Application no: H21/1059/99

Description: Erection of a rear first floor
and ground floor extension

Location: The Old Rectory
Rectory Road
Tydd St Mary
Lincs

NOTICE OF ACCEPTANCE OF AMENDMENT

FIRST FLOOR PLAN

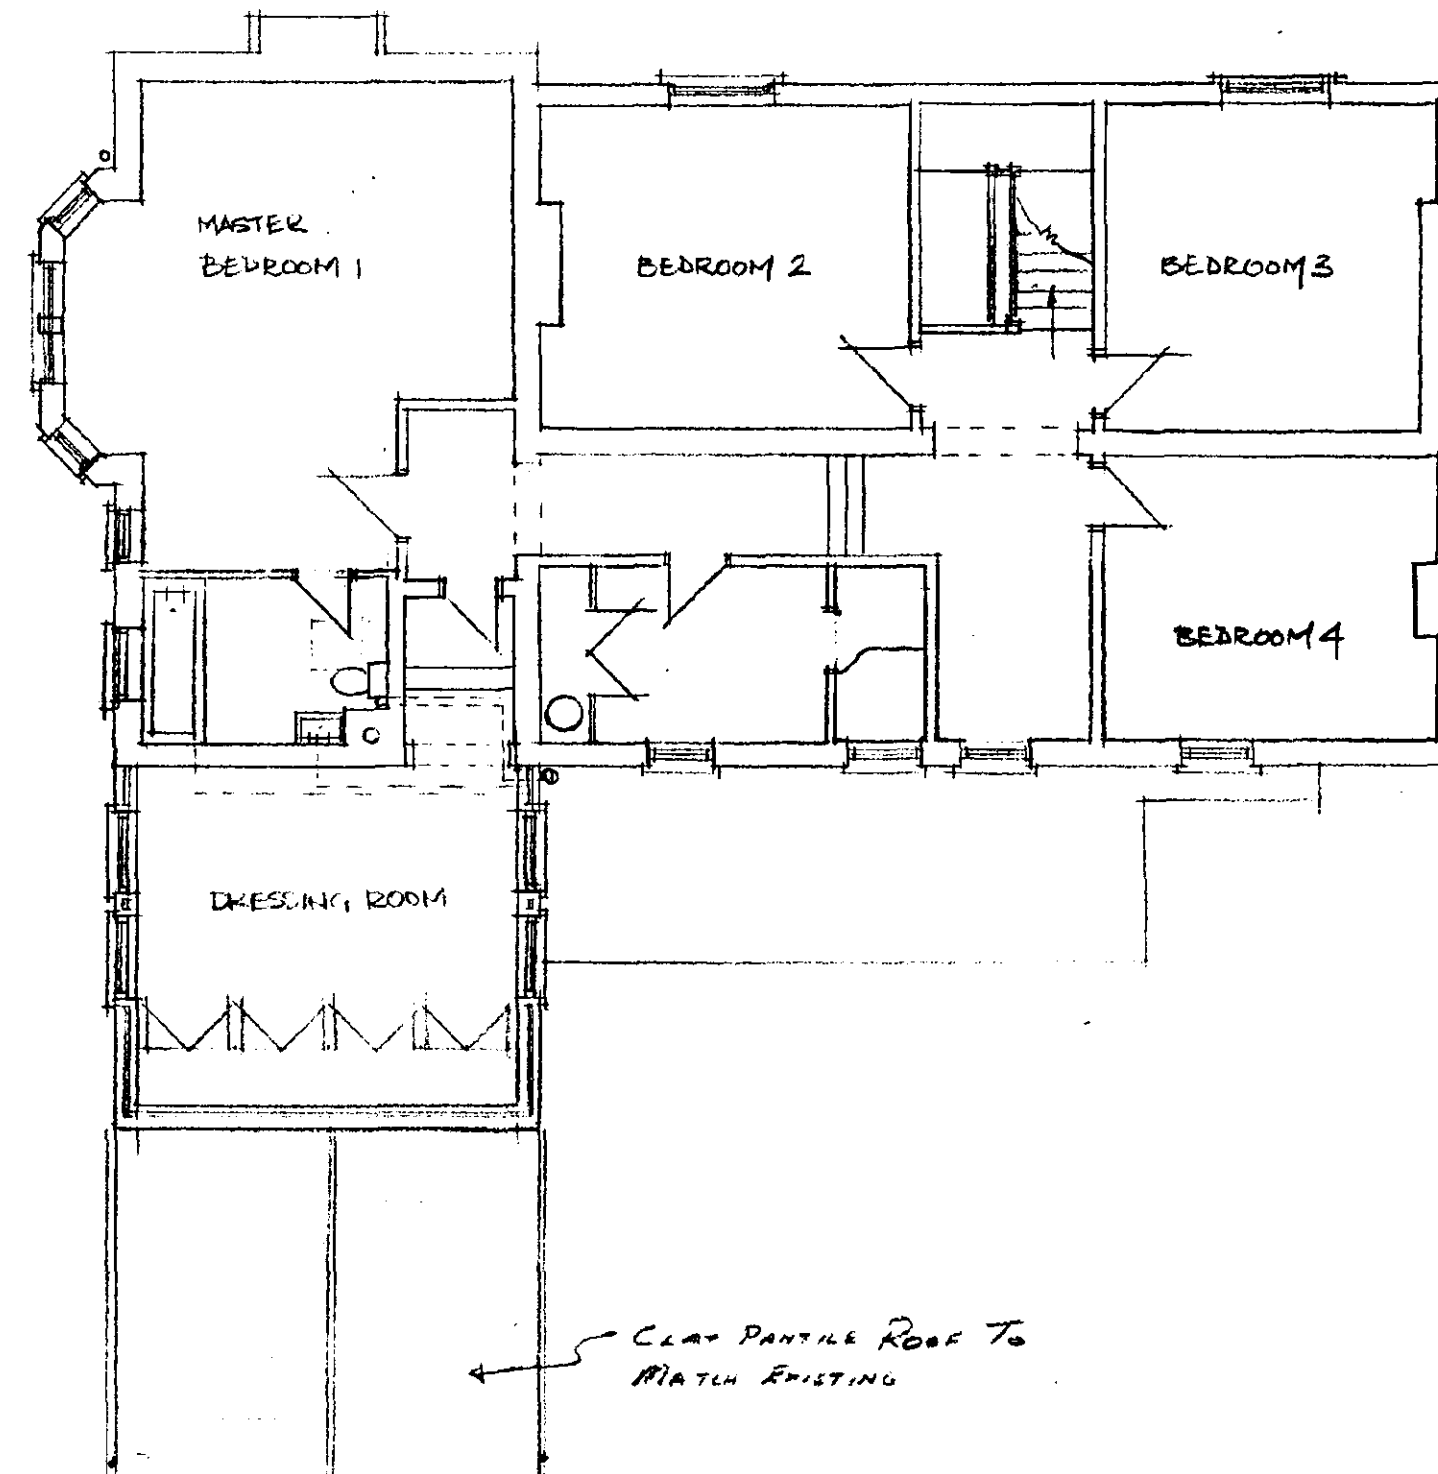
Amendment: Replace parapet/flat roof with a pitched roof
Dwg. No. 75/99/2-A

REPLACE PARAPET
FLAT ROOF WITH A
PITCHED ROOF.
